**KIRKLEES METROPOLITAN COUNCIL
INVESTMENT & REGENERATION SERVICE**

Reference No: 2020/62/94069/E

Site Address: 119A, Station Road, Shepley, Huddersfield, HD8 8DU

Description: Formation of new window openings

SIDE ELEVATION AS  
PROPOSED

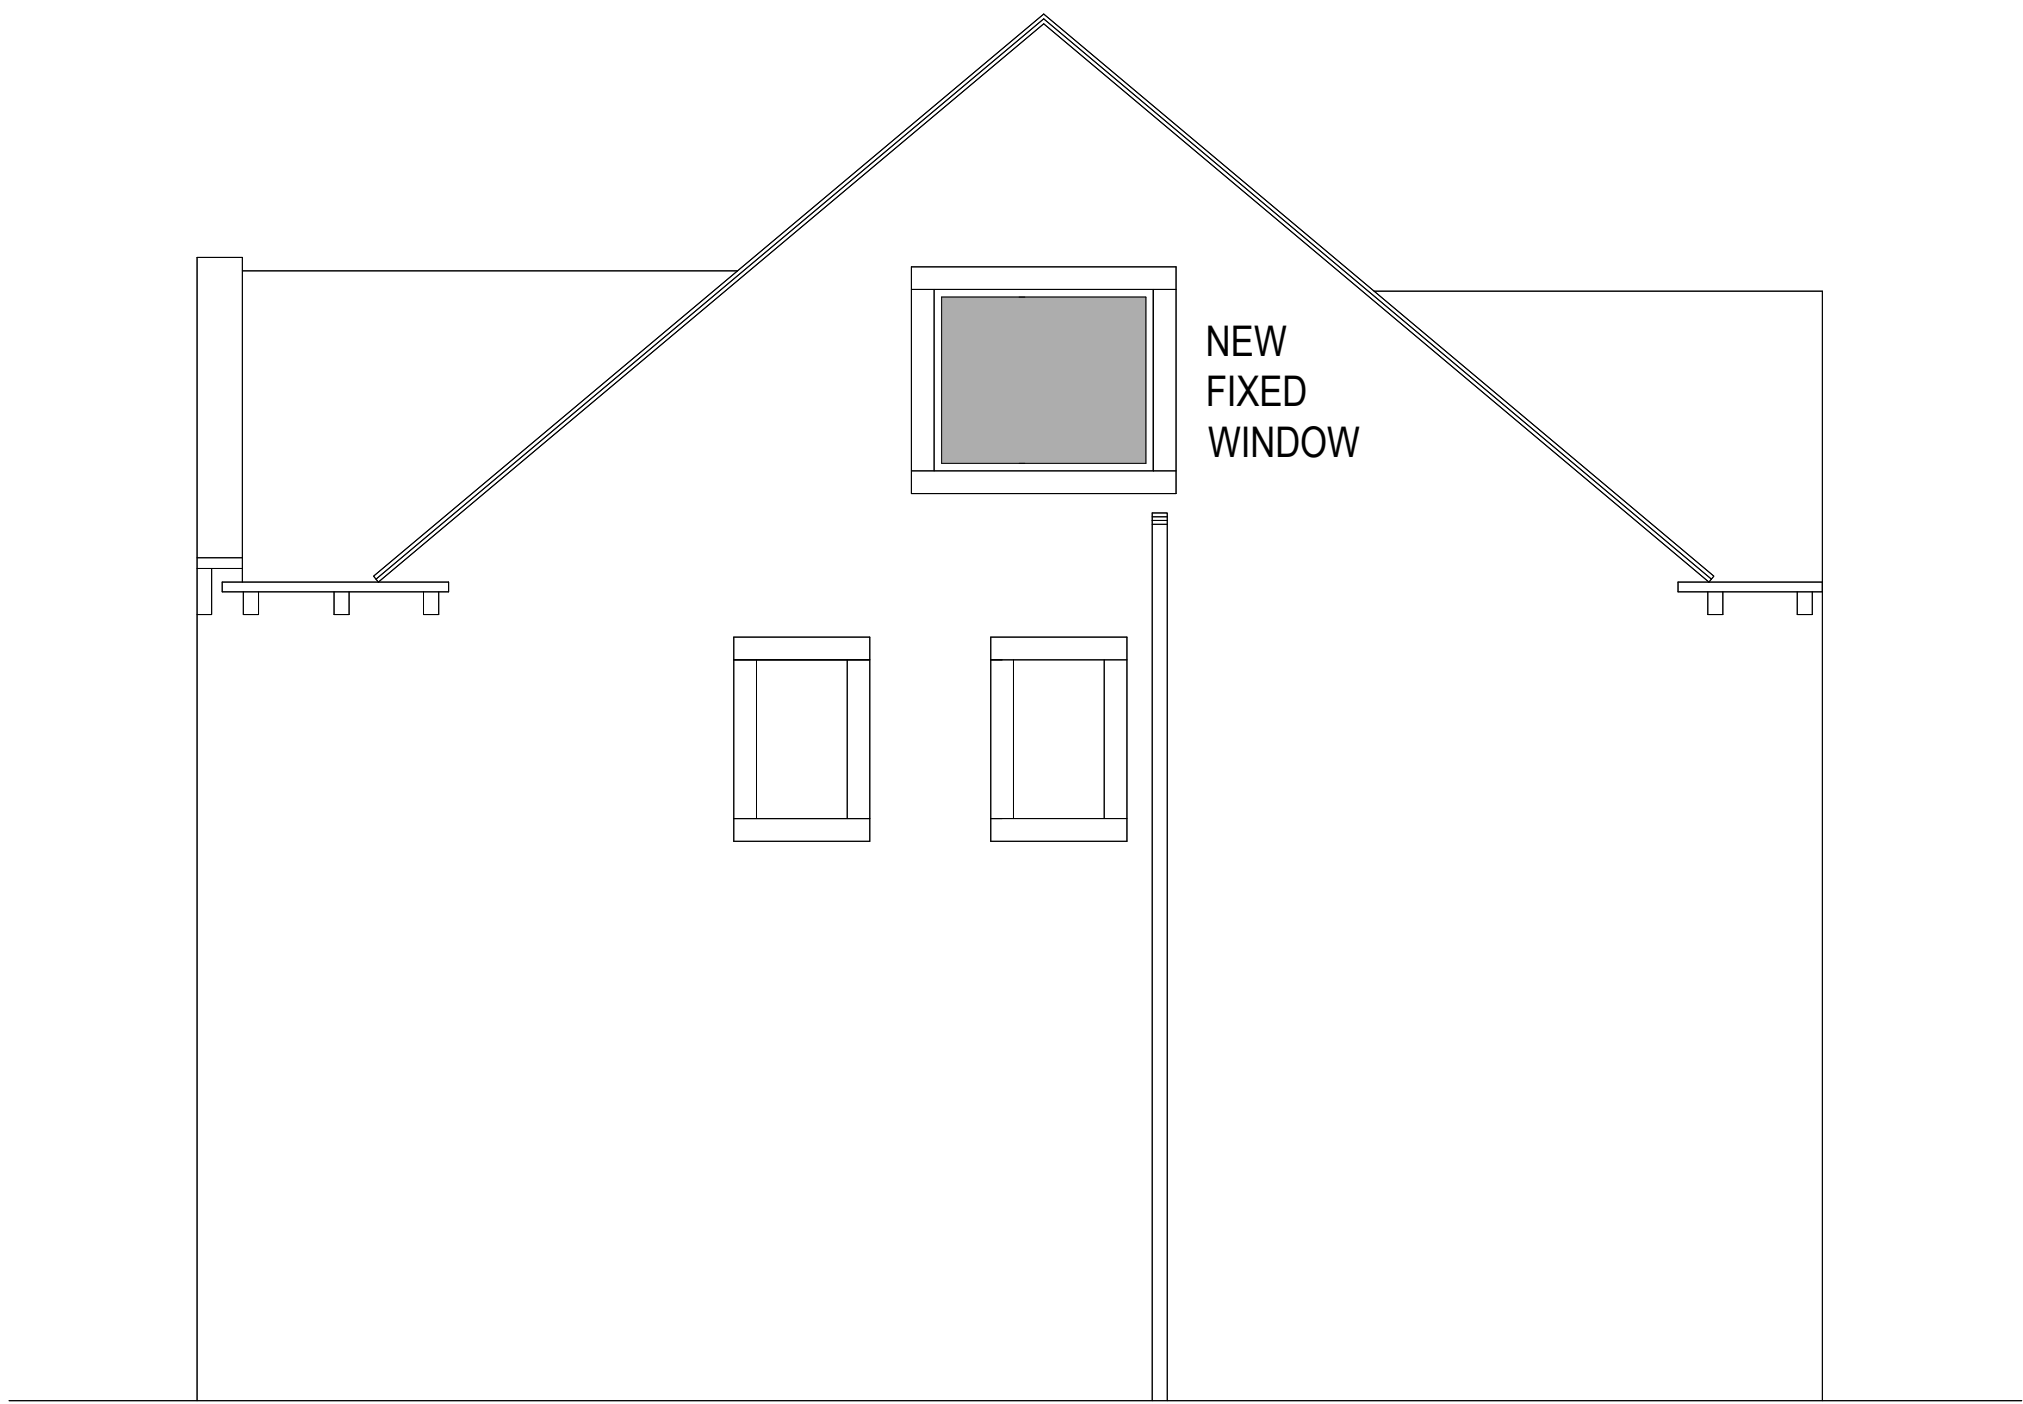
The proposed fixed window is to be set on the gable of the north-east facing side elevation. The driveway, which serves no.119 runs parallel to this elevation, with no.121 Station Road located on the opposite side of the driveway. No.121 Station Road is a bungalow with a very shallow pitched roof. Given the significant height difference (6m) between the windows of no.121 and the proposed window being discussed, there would be little privacy lost due to the inability to see within the dwellings from the windows in question. Furthermore, the fixed nature of the window restricts the ability to view down towards no.121. A condition will be added to the proposal to ensure that this window is non-opening and retained thereafter. The garden of no.121 is located to the opposite side of no.119a and, therefore, the privacy of the garden would not be harmed materially.

3. The window hereby approved on the north east facing side elevation as shown in dwg 2078 01 shall be non-opening and retained thereafter unless otherwise approved in writing by the Local Planning Authority.

REAR ELEVATION AS  
PROPOSED

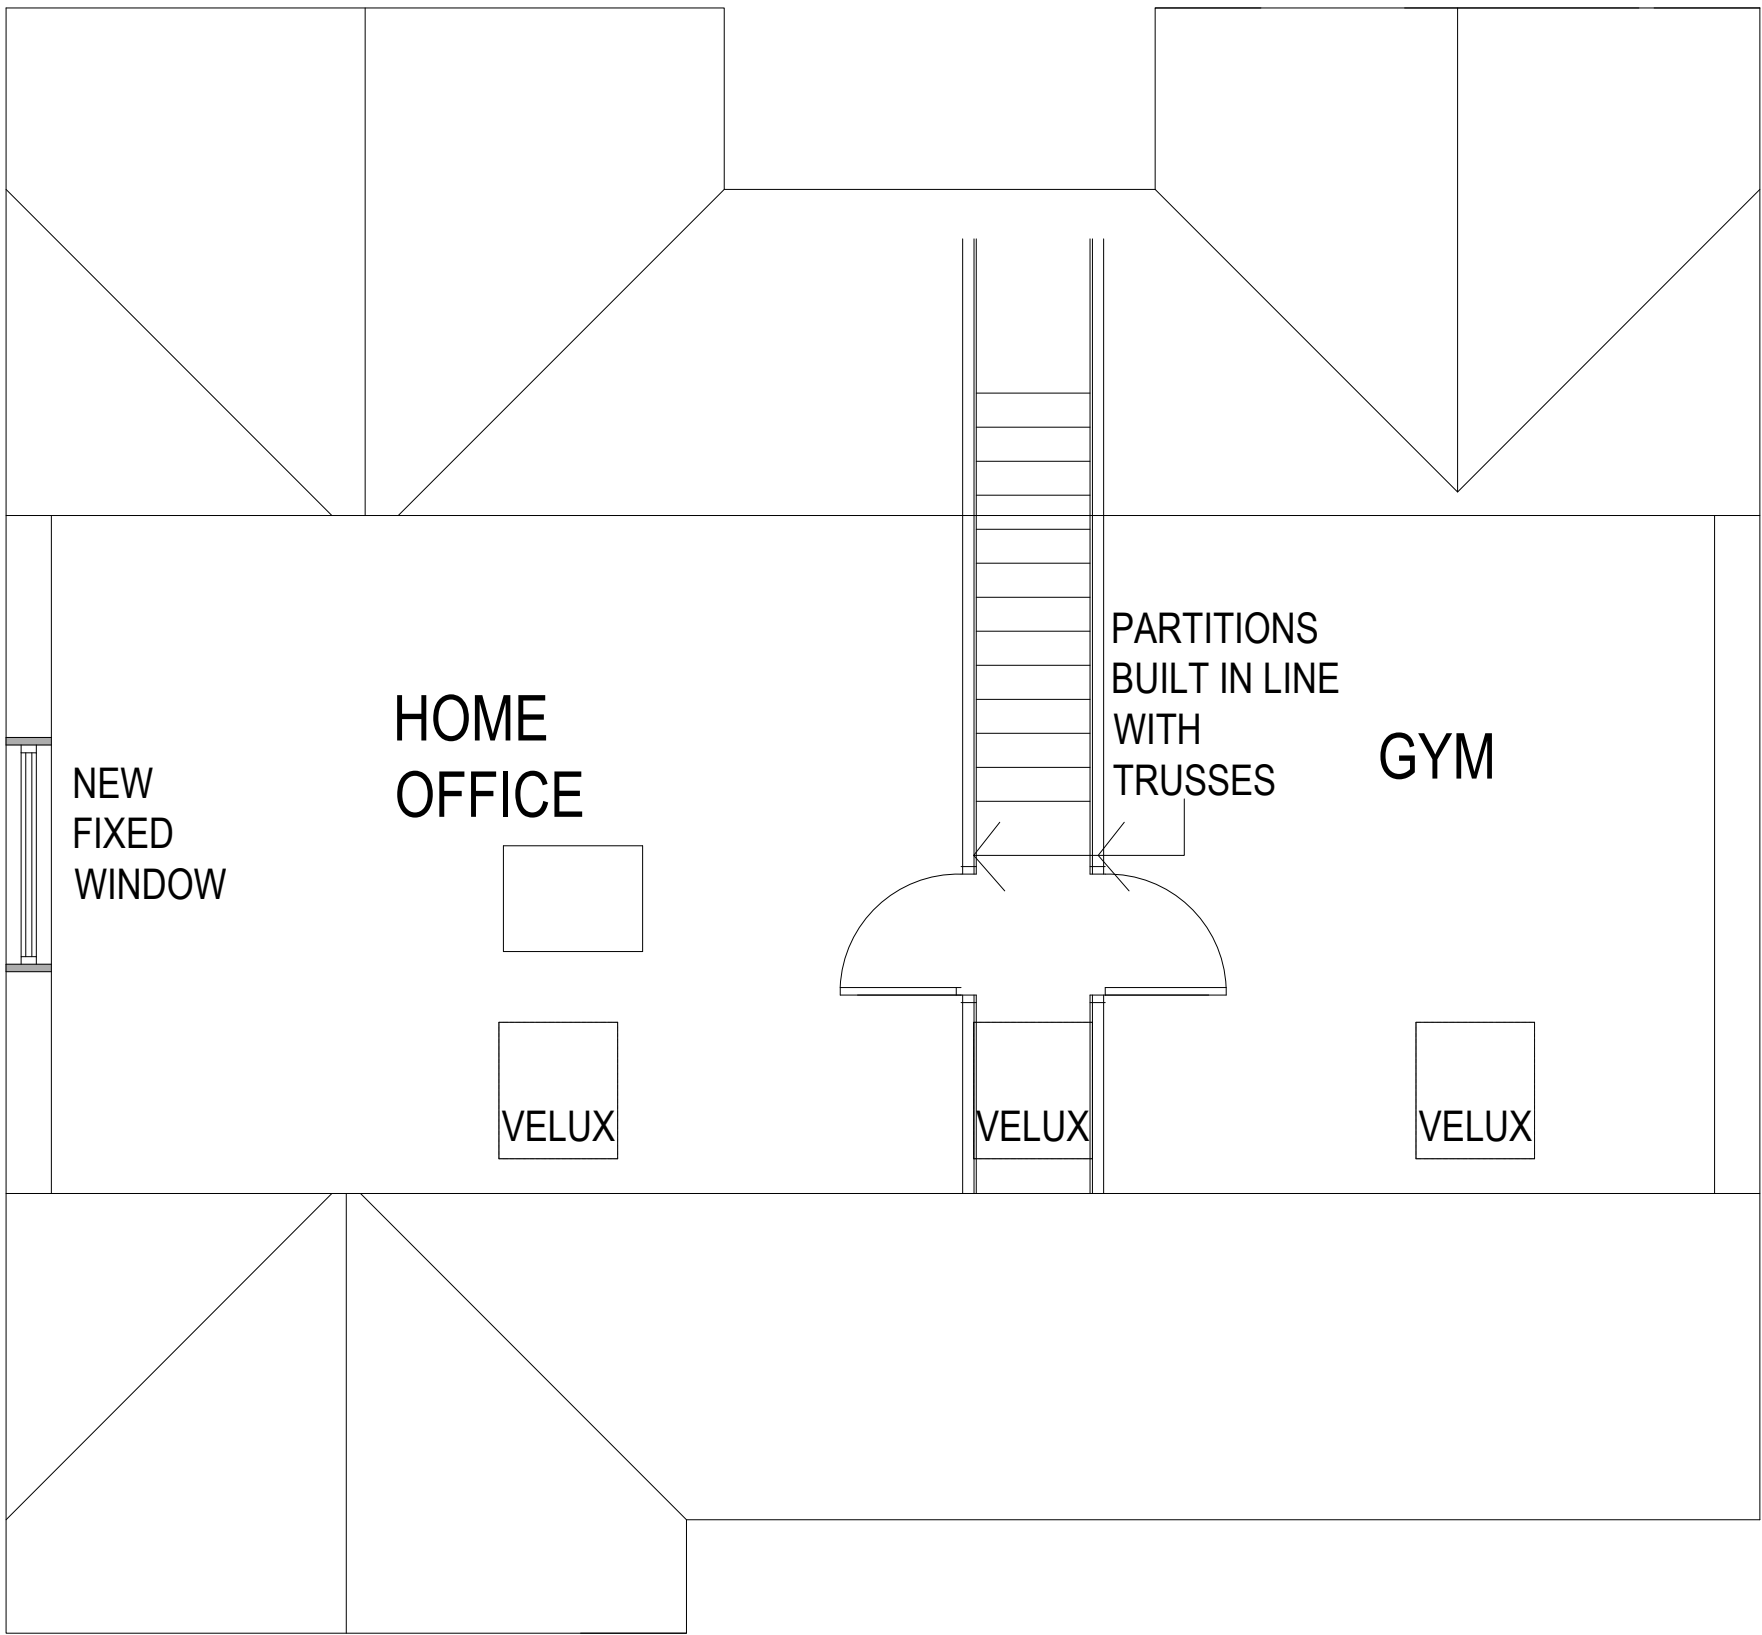
The three proposed velux windows to the rear face towards the stable block to the rear. This stable block is single storey in height and is set 14m away from the rear elevation of 119a. Whilst 119 Station Road is also set to the rear of the application site, the rear elevation of the dwelling does not face directly towards it. Furthermore, the gable in the rear elevation is set between the velux window closest to the dwelling of 119. Given this, the proposed velux windows will not cause material harm to the residential amenity of no.119 in respect of overlooking and privacy.
